**415 Cumberland Avenue - Final Traffic Comments**

**Tom Errico** <thomas.errico@tylin.com>

Hi Christian – the following represents my Final Traffic Comments:

Sheet Title:	<b>SITE PLAN</b>
--------------	------------------

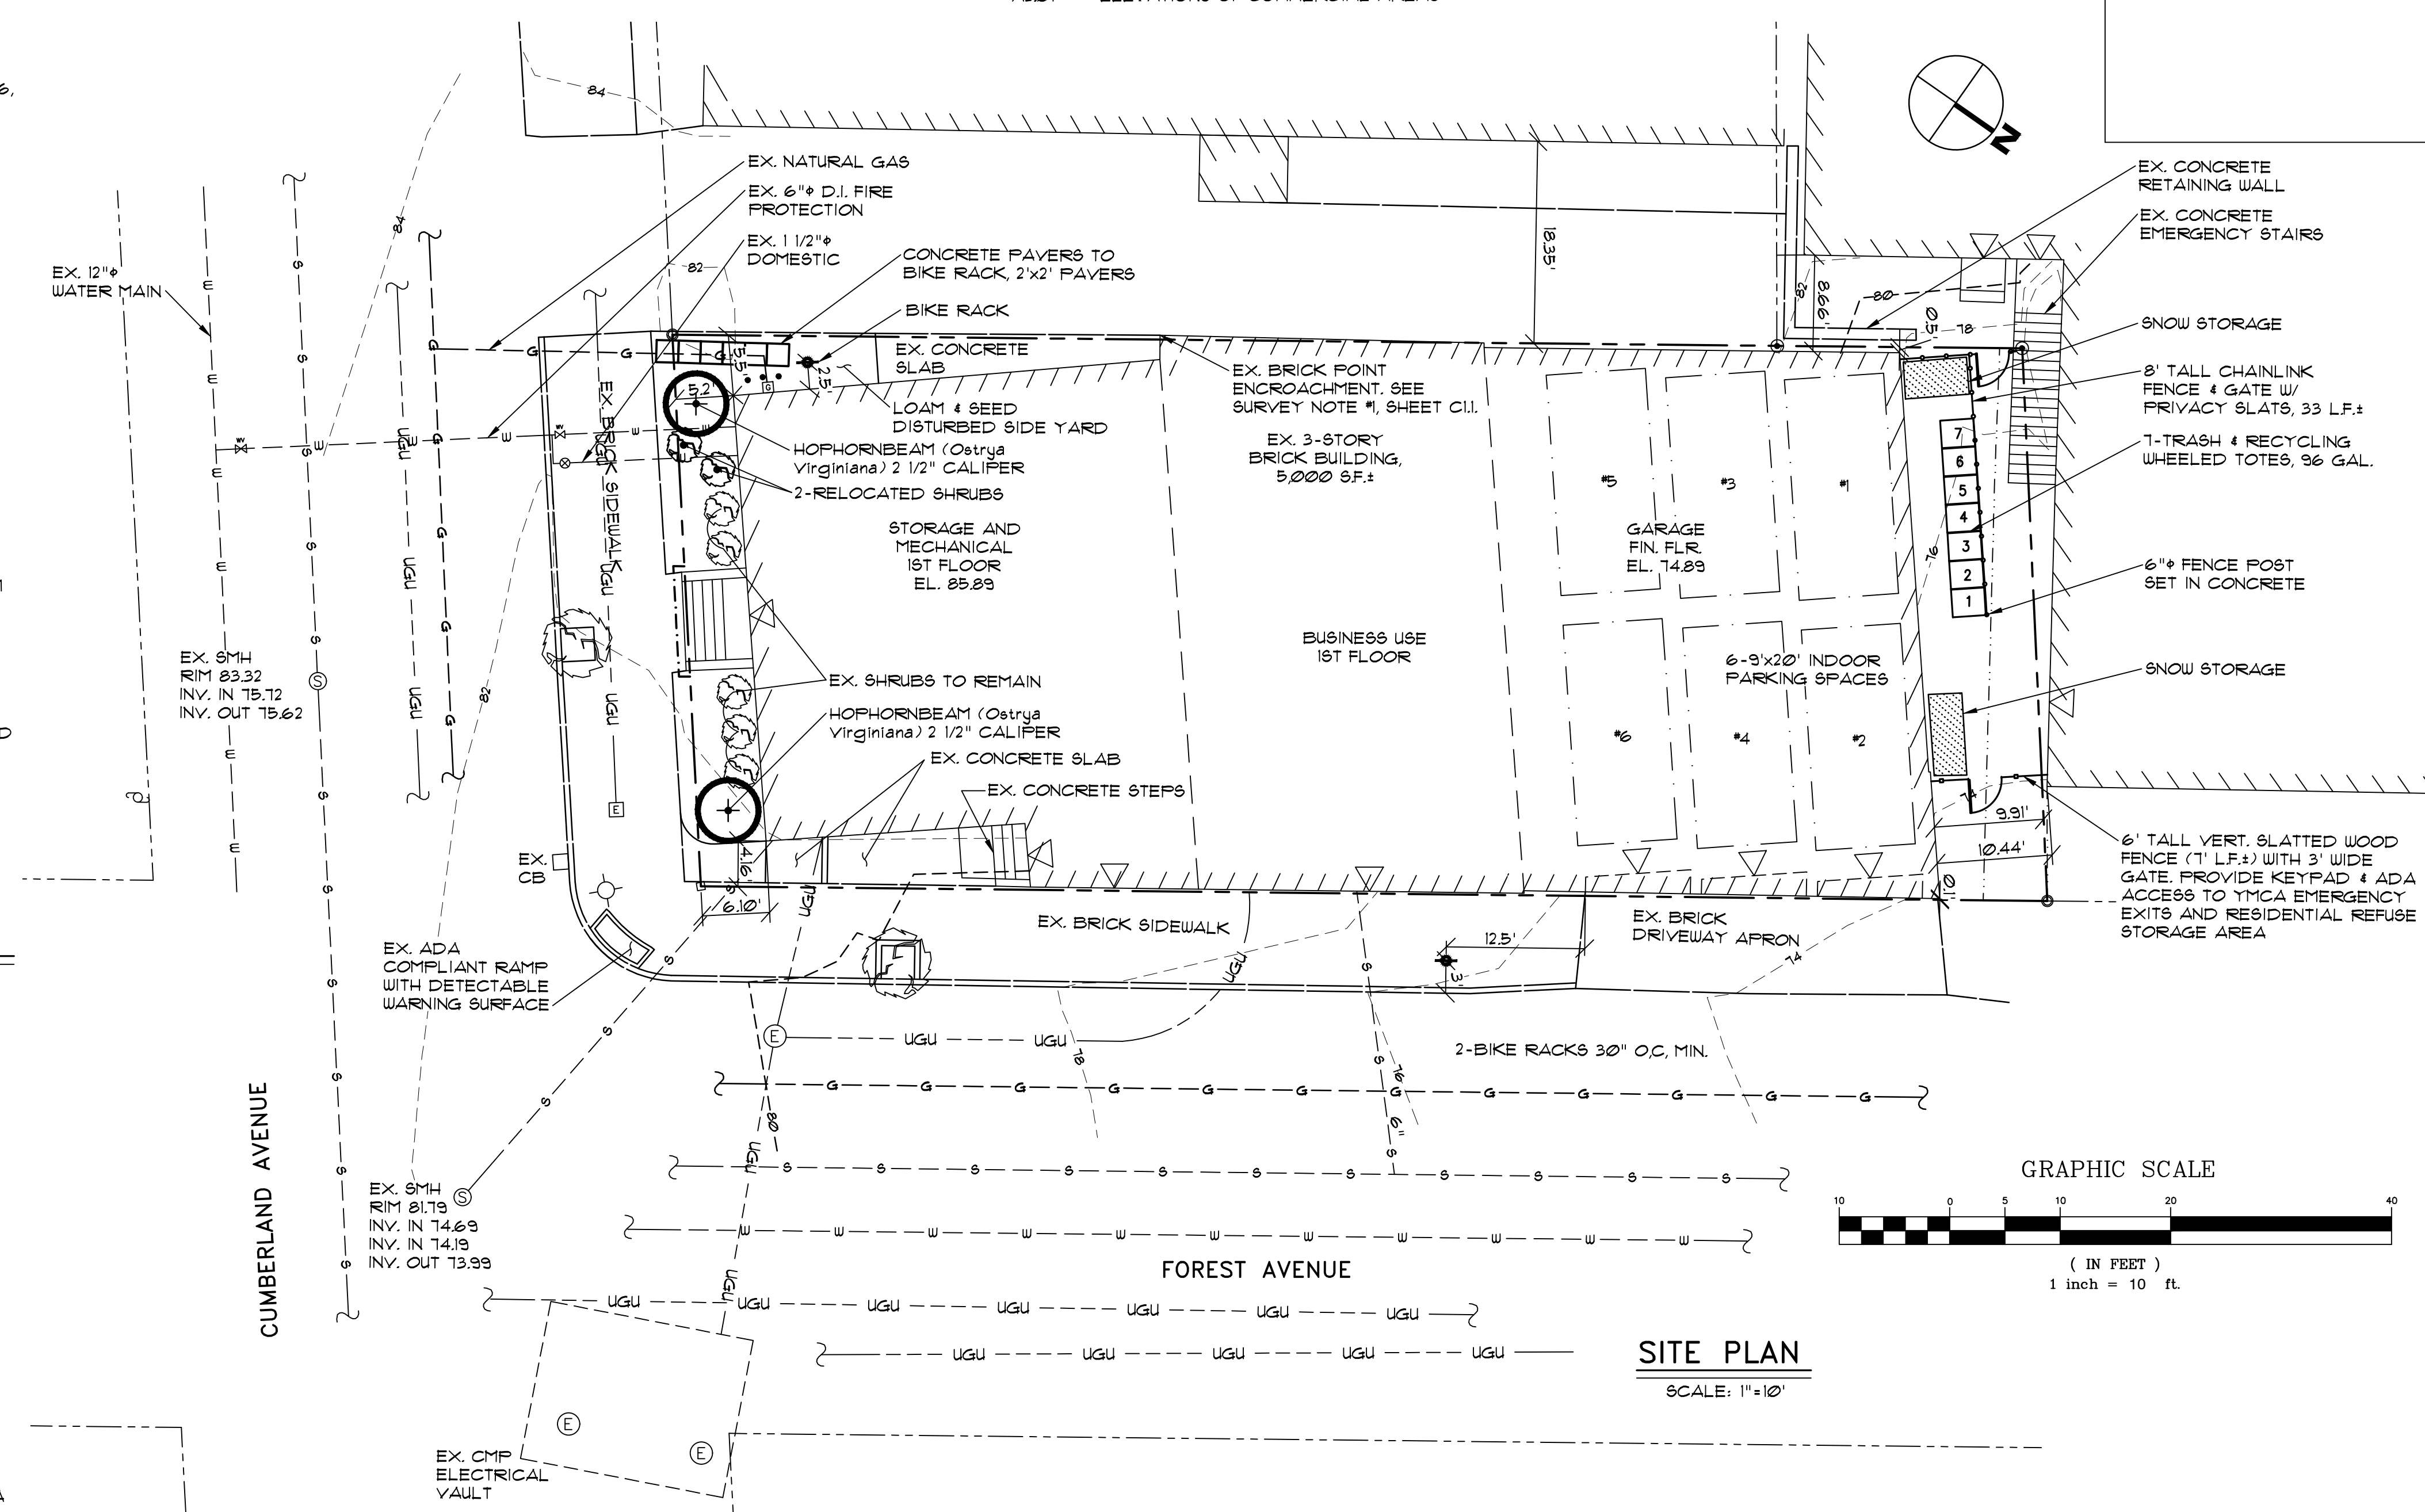
- The tandem parking spaces shall be designated for the residential units only (or for low turnover use) to ensure that backing maneuvers onto Forest Avenue are minimized given vehicle and pedestrian traffic levels.
